# CITY OF ALBUQUERQUE

**Re: Oak Street Condominiums, Lot 10, Block 22, Brownell & Lail's Addition  
Drainage Report - Engineer's Stamp dated 3-31-05 (K15-D82)**

**Re: Oak Street Condominiums, Lot 10, Block 22, Brownell & Lail's Addition  
Drainage Report - Engineer's Stamp dated 3-31-05 (K15-D82)**

OAK STREET CONDOMINIUMS GRADING AND DRAINAGE PLAN			
DRAWING: 200444-GR.DWG	DRAWN BY: SHH	DATE: 10-05-2004	SHEET # 3 OF 5

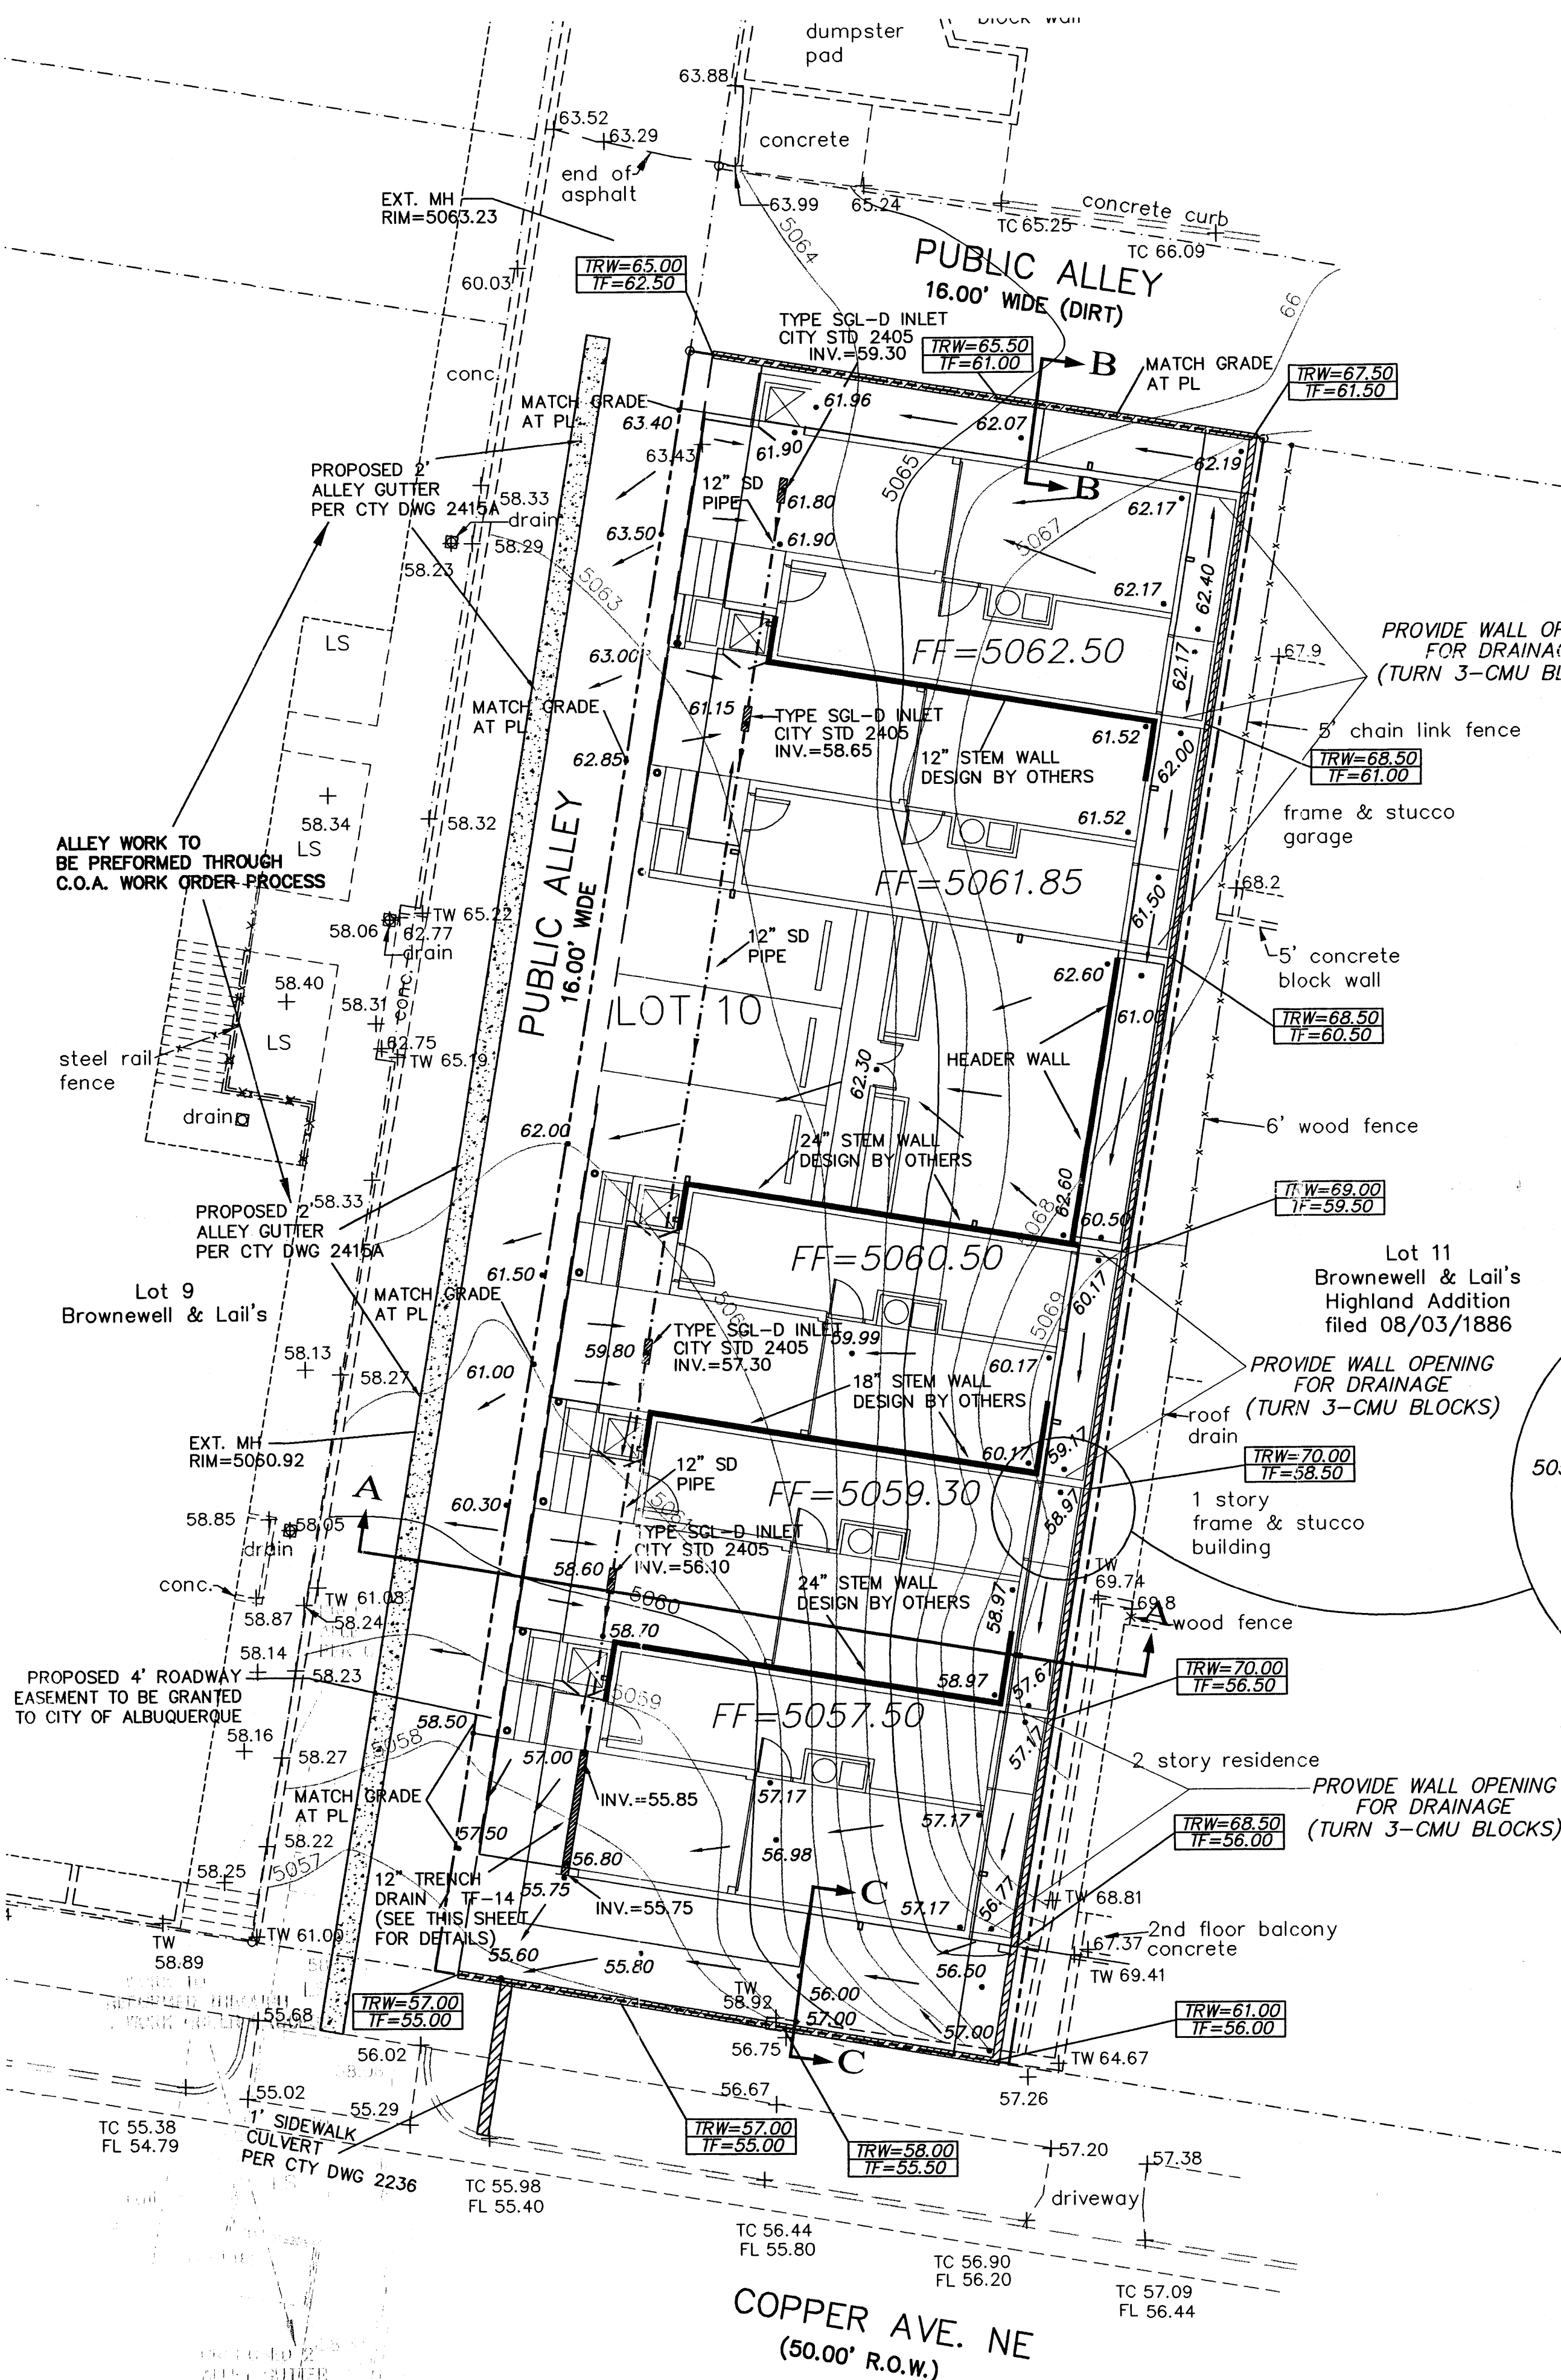
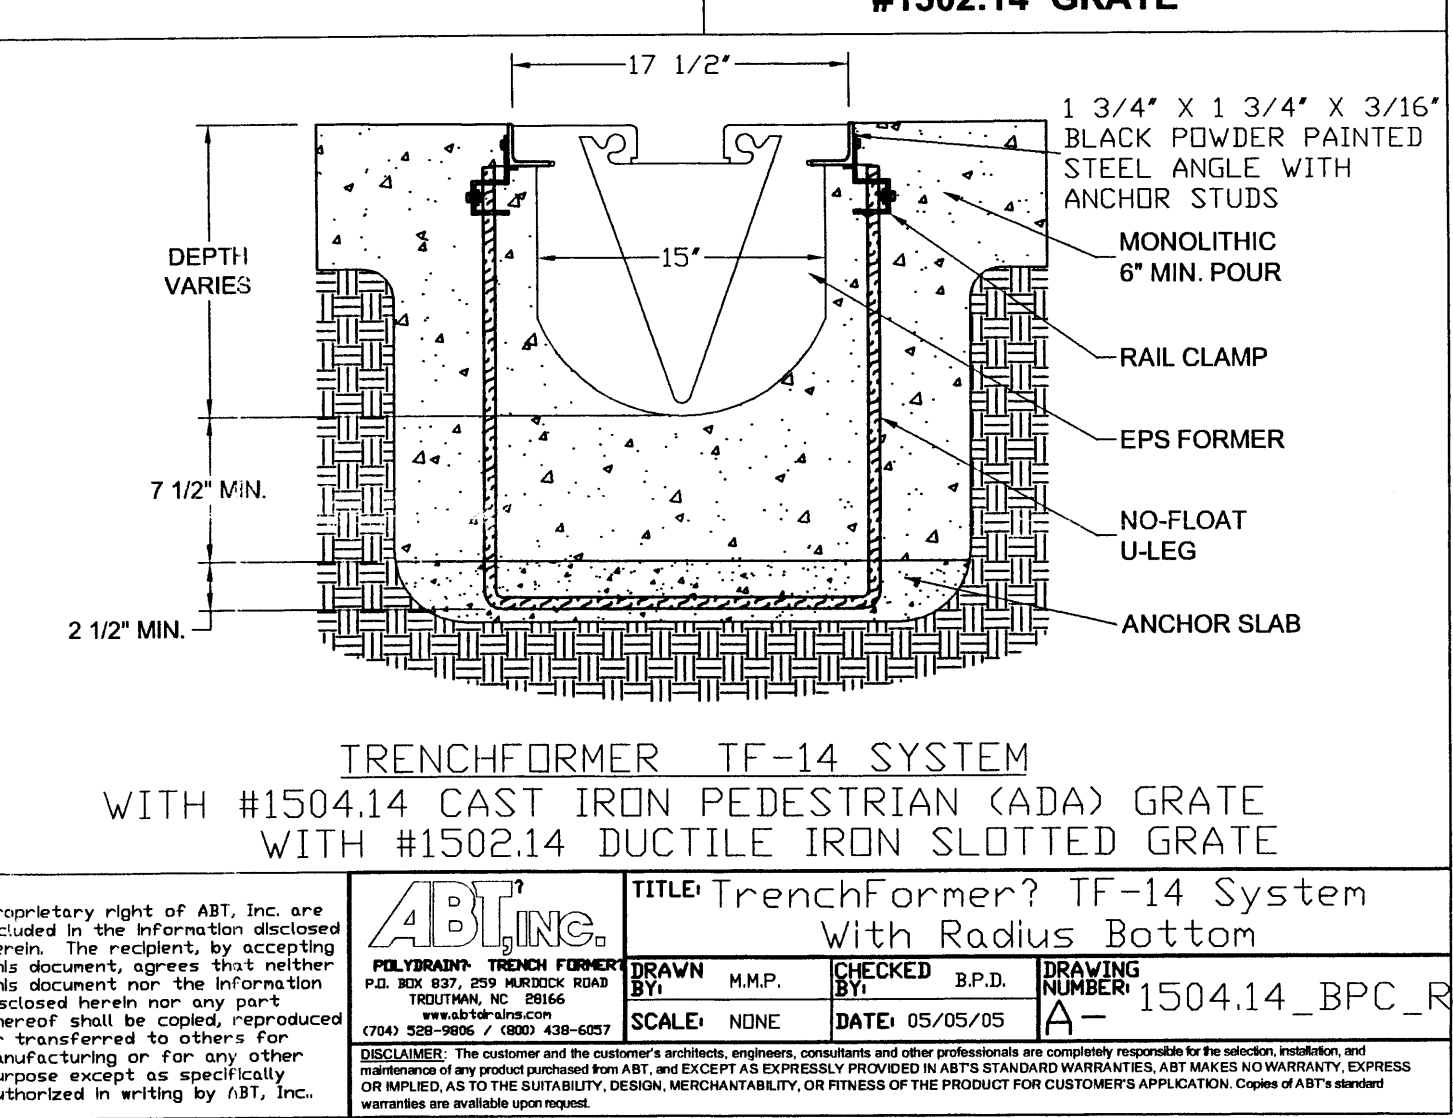
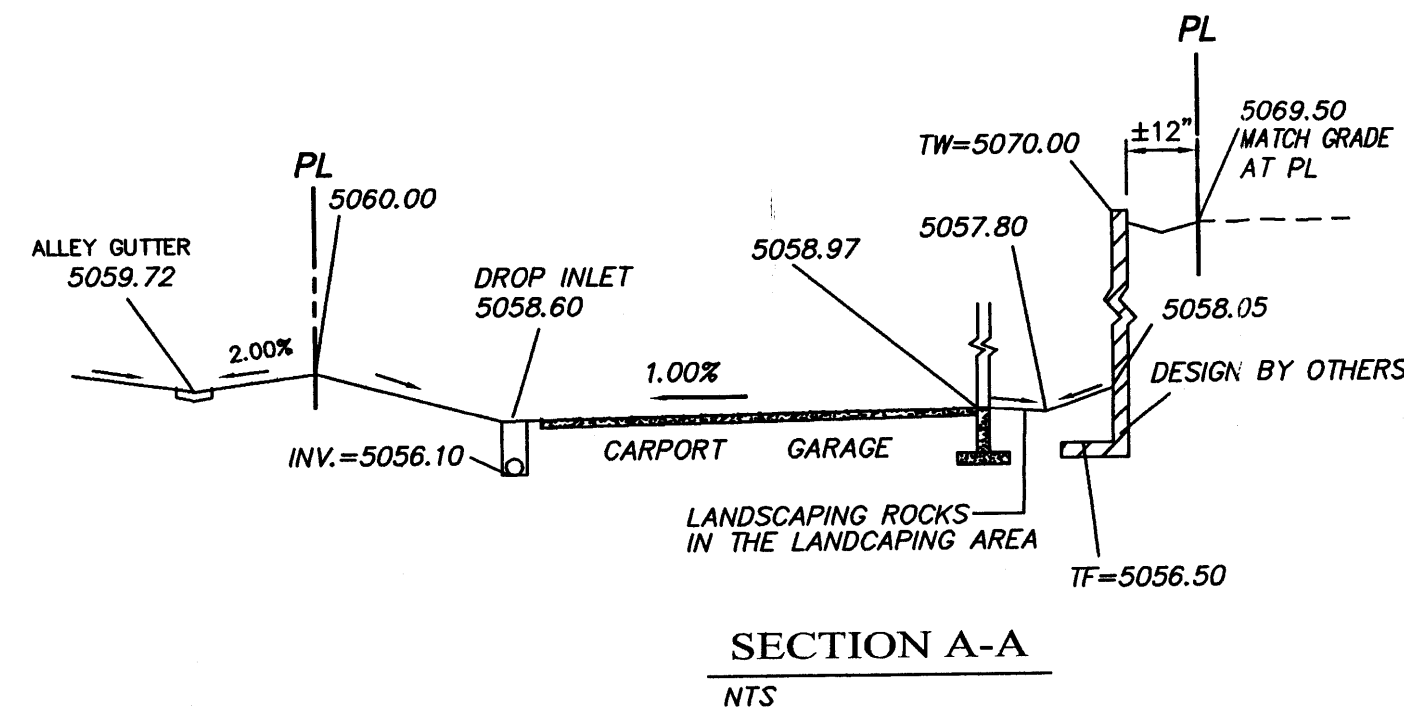
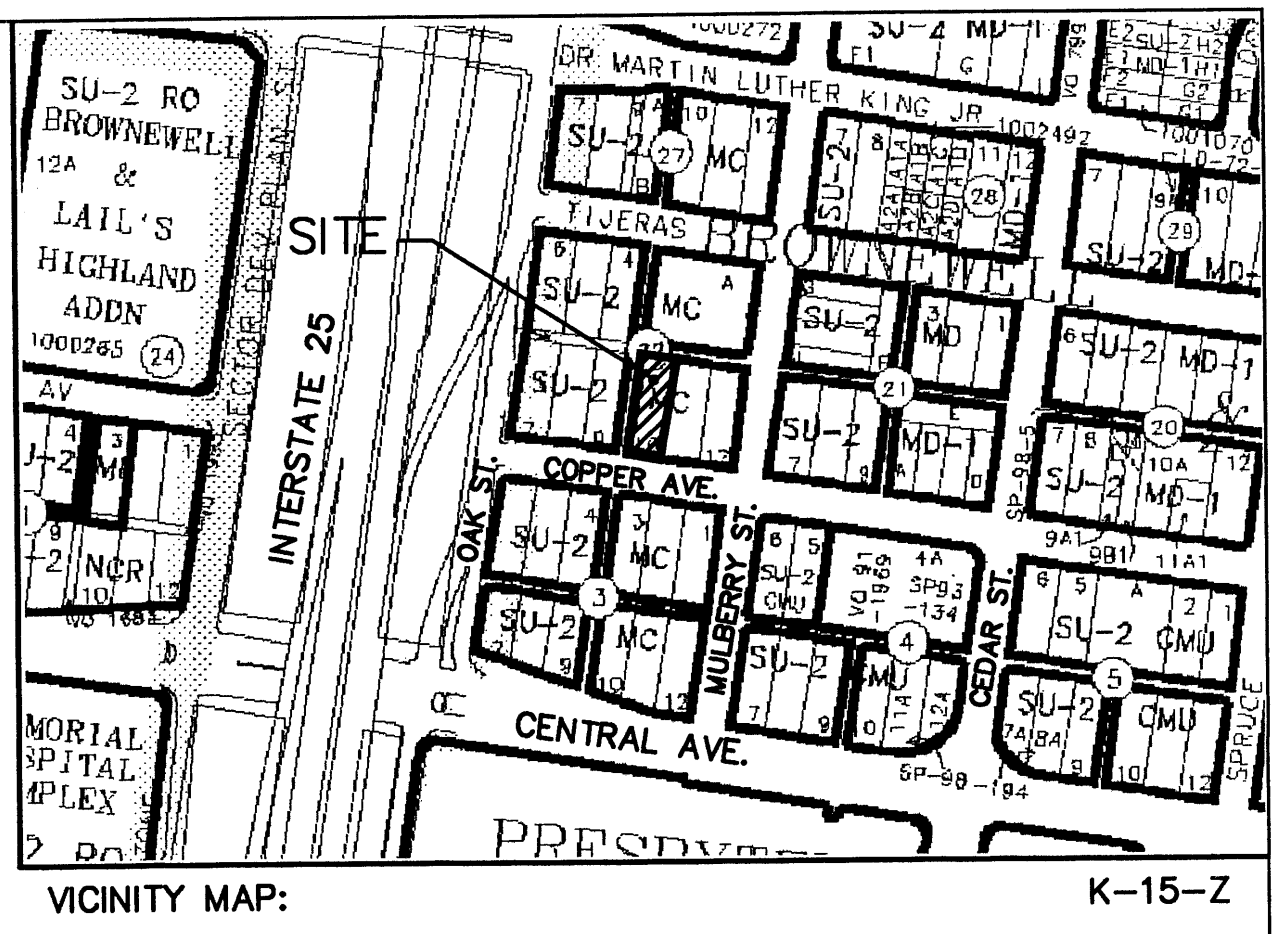
- ✓ • Provide details or reference COA Standard drawings for storm inlets, sidewalk culvert and trench drain.
- ✓ • Provide a detail for the backyard wall openings and designate each location where required on plan.
- ✓ • Add note stating that the alley improvements are to be done through C.O.A Work Order process.
- ✎ • Proposed 2' Roadway Easement needs to be recorded.

City Standard Drawing numbers are called out on the plan for the storm sewer inlets, and the sidewalk culvert. A trench detail is added to the plans (trench system TF-14).

We have added a note that 3 CMU blocks to be turned at the wall for drainage. Location of all the wall openings are added to the revised grading plan.

A note is added to the grading plan that the Alley construction work has to be done through C.O.A. Work Order process.

The easement has been changed to a 4' easement. We are in the process of preparing the easement. As soon as the easement is finalized and recorded we will forward you a copy.
